Re: **PA23-023 – Spitzenberg Apartments**
IECO No. 23-1280

The project referenced above is revised in response to the review comments dated November 6, 2023. The review comments are numbered on the letter and have been addressed in *italics* as follows:

SITE PLAN

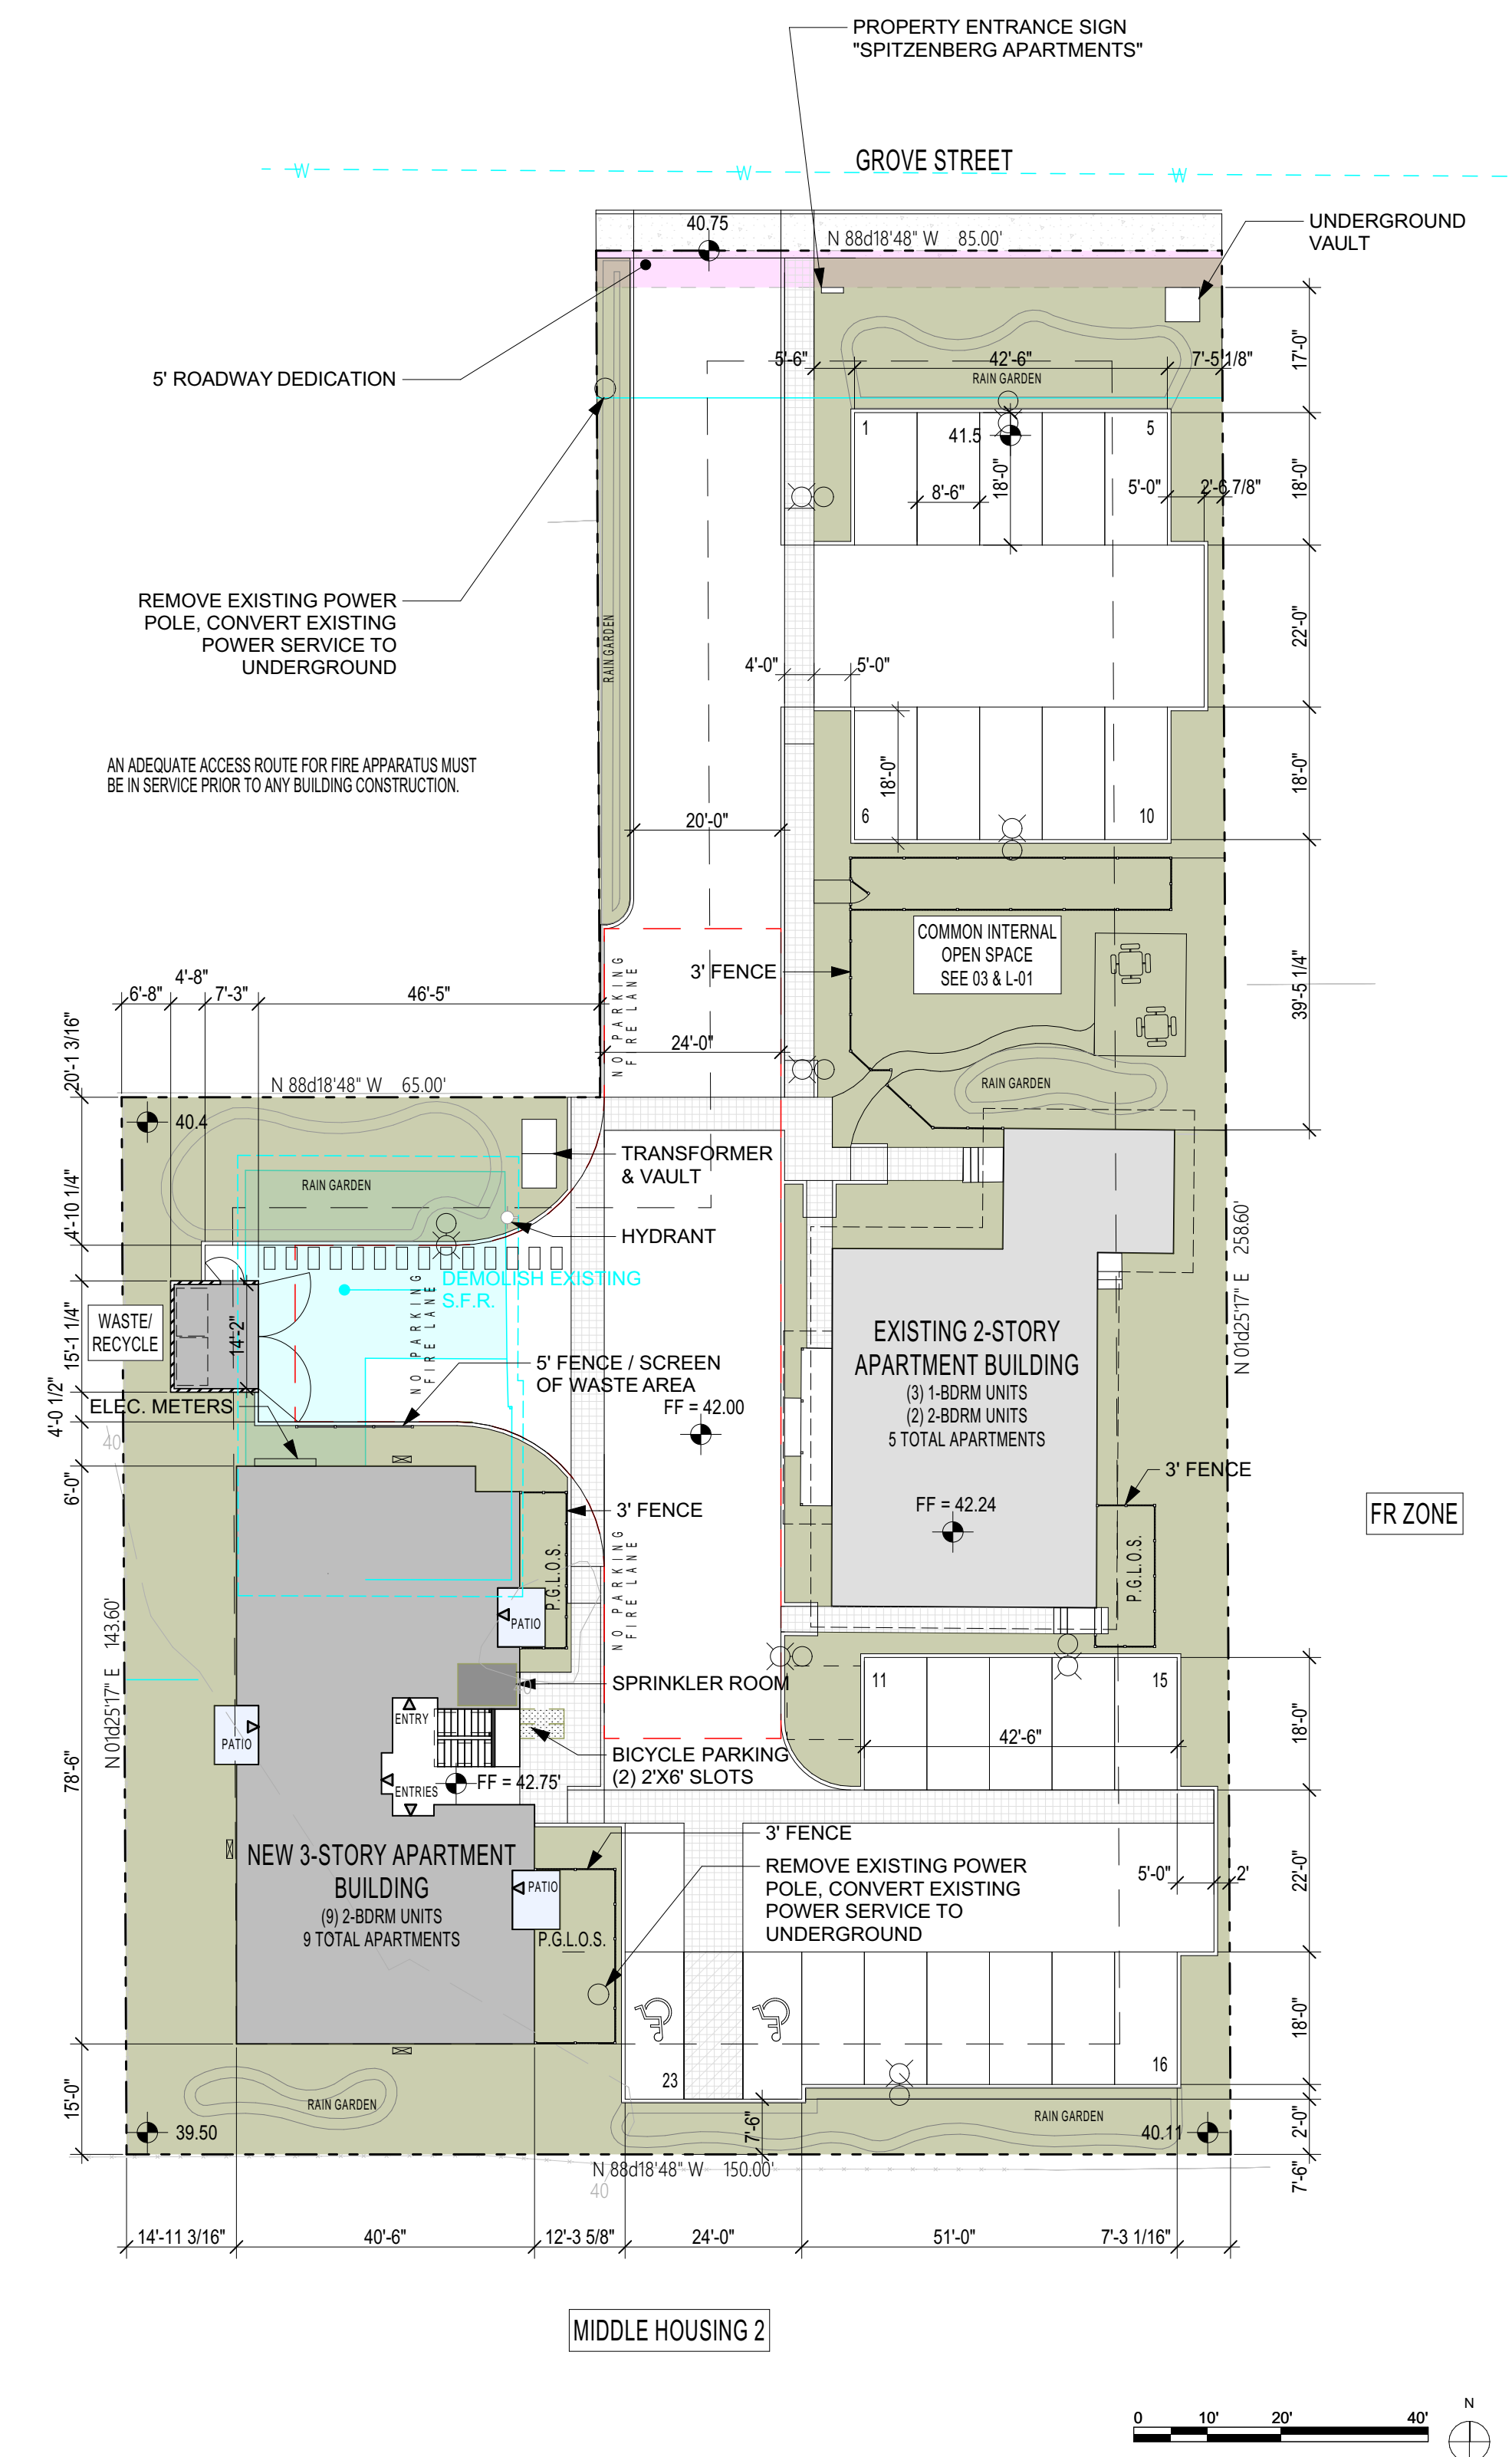
1. A clearly defined walking path shall be provided to the dumpster enclosure. As currently proposed, it appears a resident would have to walk in the rain garden in order to access the pedestrian door for the enclosure.

Please see revised plans.
